**KIRKLEES METROPOLITAN COUNCIL
INVESTMENT & REGENERATION SERVICE**

DELEGATED DECISION TO DETERMINE PLANNING APPLICATIONS

Reference No:	2024/62/91209/W
Site Address:	17, Wood View, Birkby, Huddersfield, HD2 2DT
Description:	Erection of single storey and two storey side and rear extension and conversion of existing garage
Recommending Officer:	Molly Storer

DECISION – FULL CONDITIONAL PERMISSION

**Proposed Ground Floor Plan**

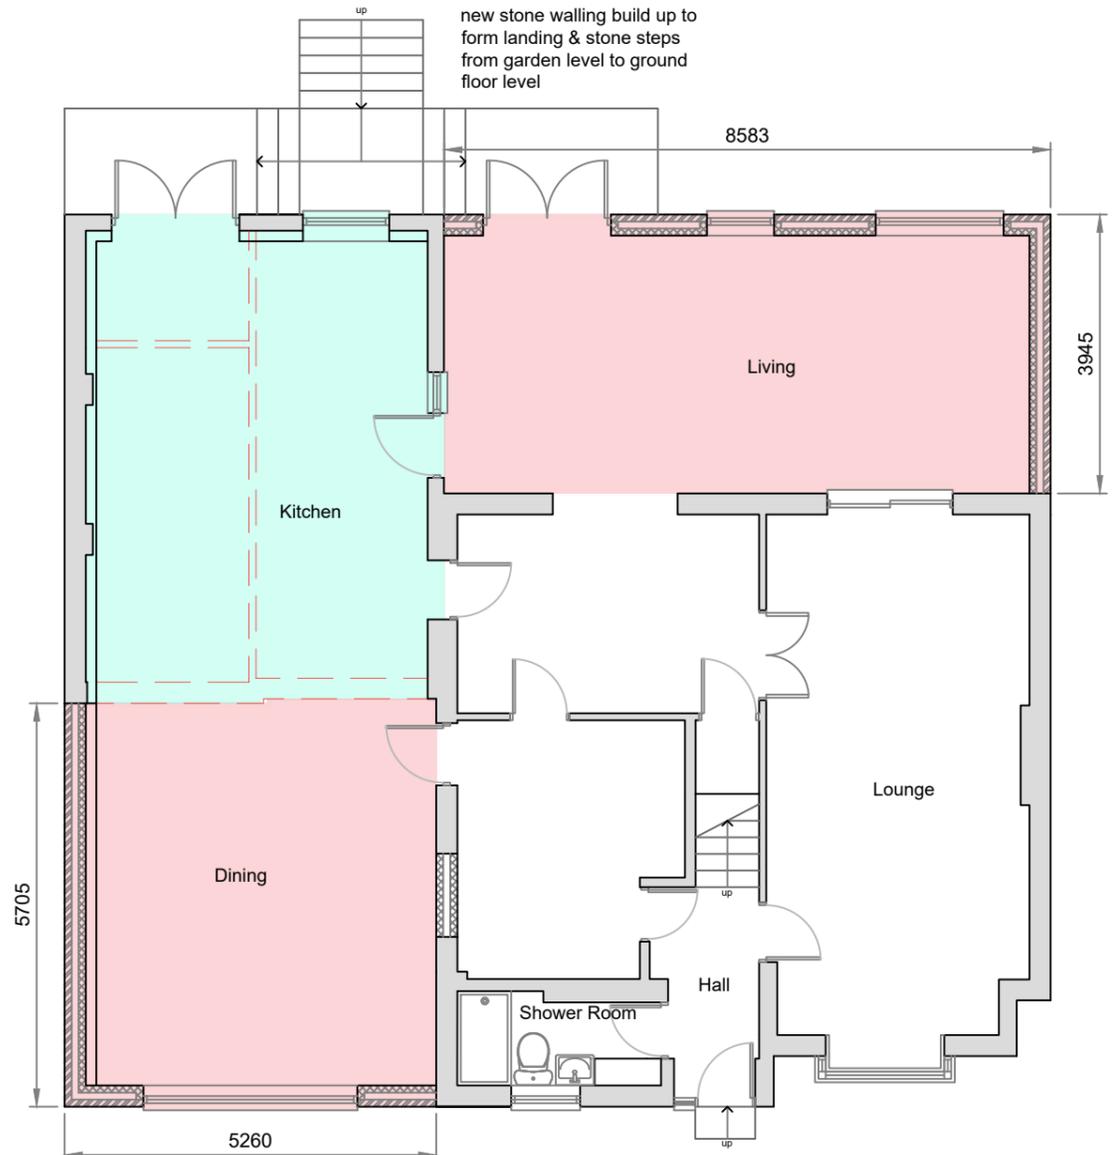
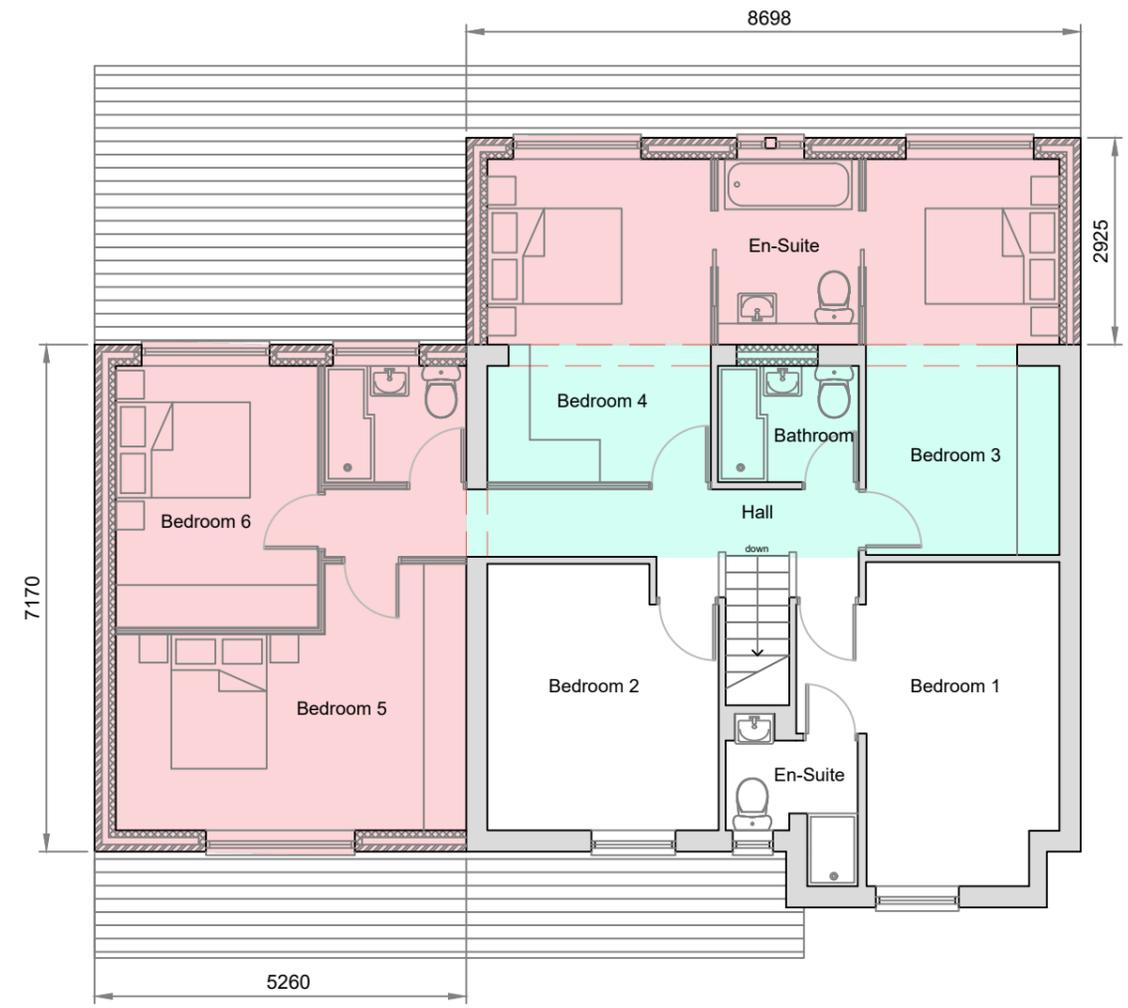
The proposed development to the side will consist of a part two storey, part single storey extension. The single storey extension will project 5.26m from the west facing side elevation and will have a width of 5.705m. The height to the eaves will be 2.5m with an overall height of 3.4m this will create space for a dining room.

The two storey element will project 5.26m from the west facing side elevation on the first floor and will run the width of the original dwellinghouse (7.170m). The height to the eaves will be 5.1m with an overall height of 7.3m. the roof design will be a gable roof which will create space for two extra bedrooms and a bathroom.

The garage, located to the side of the property (towards the rear) is proposed to be converted into a kitchen area which will adjoin the dining area being proposed in the single storey side extension and the living area being proposed in the single storey rear extension.

The proposed development to the rear will consist of a part two story, part single storey extension. In this instance the single storey element will project 3.945m from the rear north facing elevation and will have a width of 8.65m.

In this instance a 1 metre gap will be maintained between all elements of the proposal and the site boundary except from a narrow point where the side extension meets a curve in the boundary line (although a 0.9m gap will still remain) so is therefore considered acceptable in this instance. Furthermore, given the extent to which the proposed extensions will harmonise with the host dwelling in relation to appearance and form (with matching materials and eaves heights), the proposed works will be visually appropriate and therefore, will be subservient when viewed in conjunction with the host dwelling.

The single storey element to the front and the garage conversion to the rear will not exceed the projection of the existing garage and therefore will appear modest when viewed from the front elevation. The single storey element will not exceed 4m in height not extend more than two thirds of the width of the original house. Although it will not be set back the alignment with the front elevation allows for a harmonious design. Access to the rear garden will be maintained.

The proposed works will increase the domestic use of the dwelling, as the number of bedrooms will increase by two and the garage space being converted. However plans show that three off-street parking spaces will be made available to the front of the property on the driveway. Therefore, it can be concluded that a sufficient extent of parking is retained at the property.

Proposed South Facing Front Elevation

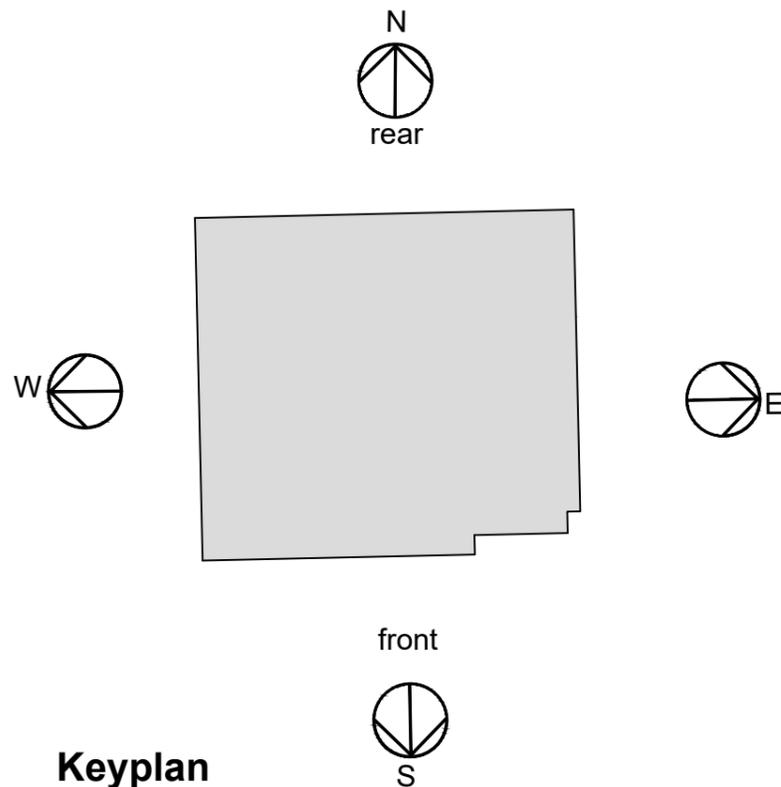
Due to the topography of the site, whereby the house is situated on a significantly higher ground level than the rear garden, the eaves height will be 4.2m with an overall height of 4.7m when measured from the garden level. This will create space for additional living space on the ground floor and will be accessed via stone steps from the garden level to the ground floor level.

The two-storey element will be built above the single storey extension but will only project 2.925m from the rear wall of the first floor and will have a width of 8.65m. The extension will have two gabled roofs each measuring 2.8m to the eaves and 4m to the ridge when measured from the roof of the single storey rear extension. Overall, the maximum height from the garden level will be 8.6m. The gable roofs will be set down from the original buildings roof height by 0.5m. This will create space to enlarge two original bedrooms and an extra bathroom.

situated) the single storey rear extension has a modest eaves and overall height. As for the two storey rear extension the ridge is set down from the original roof ridge by 0.5m to appear subservient to the dwelling. Although the rear elements do not adhere to all principles set out in the SPD in this isolated case the extension is considered acceptable due to the large plot in which the dwelling is situated and due to having a built up boundary treatment resulting in the rear extension creating no visual harm to the street scene.

With regards to the side element of the proposal, the first floor element will be set in from the front elevation by 0.8m and although it won't be set down the roof ridge and eaves height will match that of the existing property and with the windows on the first floor aligning with those on the existing first floor will create a visually harmonious design.

In terms of privacy there is extra glazing proposed to the north, rear elevation facing in the direction of this property. However, it is considered that due to the existing glazing in this elevation, the additional glazing (being brought forward by 4m) will not cause significant additional harm and is not a reason for refusal. In addition, due to the siting of the property's, some level of shading may occur in the very early hours of the summer months however this is not considered significant to refuse the application. Finally, as a result of the proposed works a 4m gap will be retained to the boundary with this property and a 9.5m gap between the extension and the property at this site.

Proposed West Facing Side Elevation

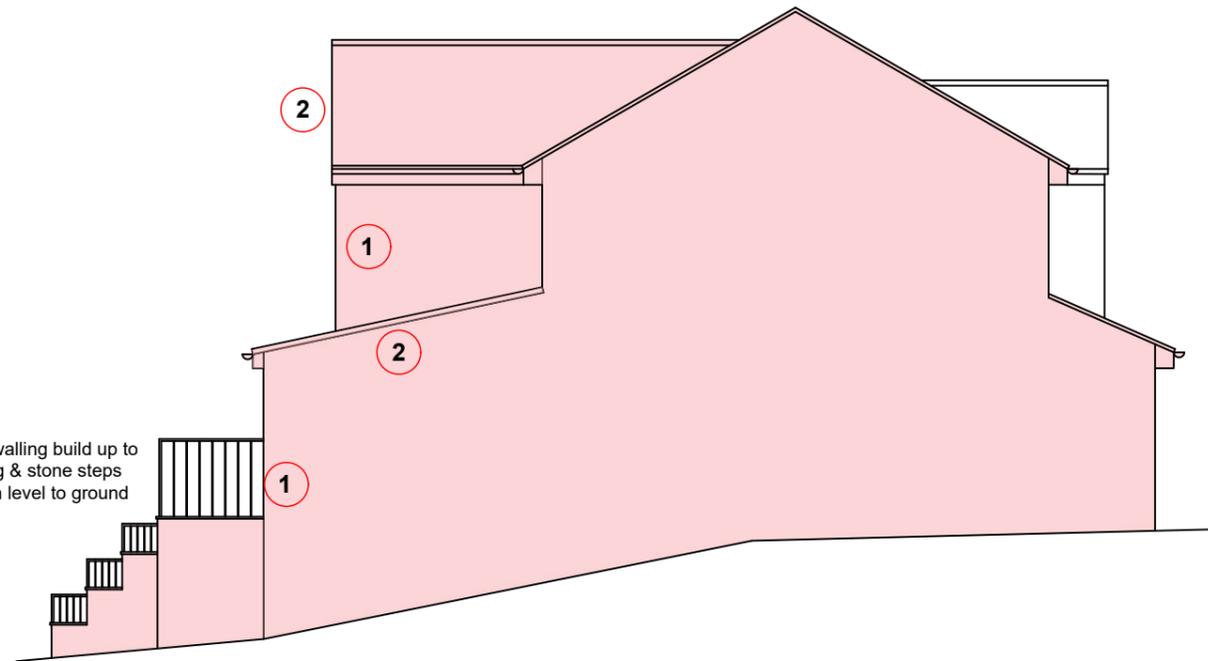
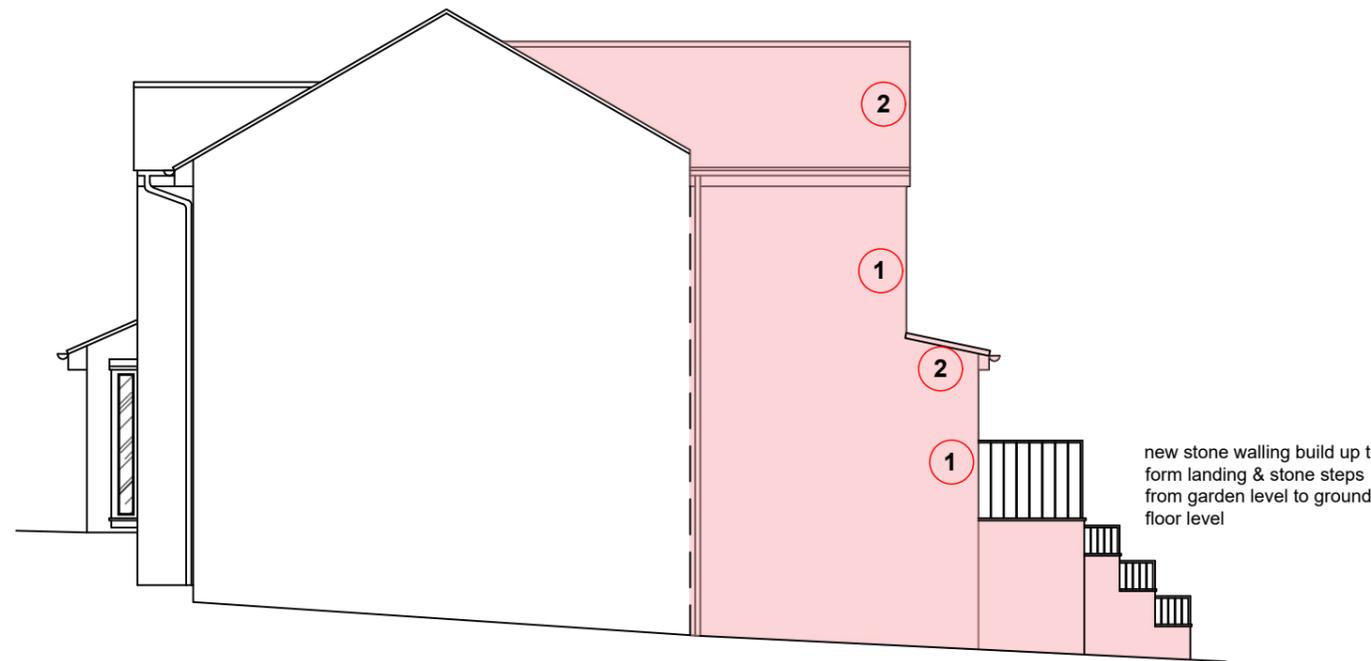
With regards to privacy, although a 1m gap to the boundary will not be maintained, an extent of separation distance will be retained between the two neighbouring properties on the sites. In addition, no glazing is proposed on the side elevation of the single storey rear extension and therefore, the rear extension poses no detriment to neighbouring privacy in terms of overlooking.

Finally, the first-floor extension poses no detriment to neighbouring privacy in terms of overlooking as the window proposed in the side elevation will be obscurely glazed.

In terms of privacy, no glazing is proposed in the side elevation of the side extension or garage conversion so privacy will not be significantly impacted. It should be noted that No.15 is set on a significantly higher ground level and is set forward of the application site resulting in a separation distance of over 10m between the extension and the property at No.15 therefore there will be limited overbearing or overshadowing impact. Finally, it should also be acknowledged that boundary treatment is erected between the application site and this neighbouring property, in the form of tall wooden fencing, further mitigating any potential impacts.
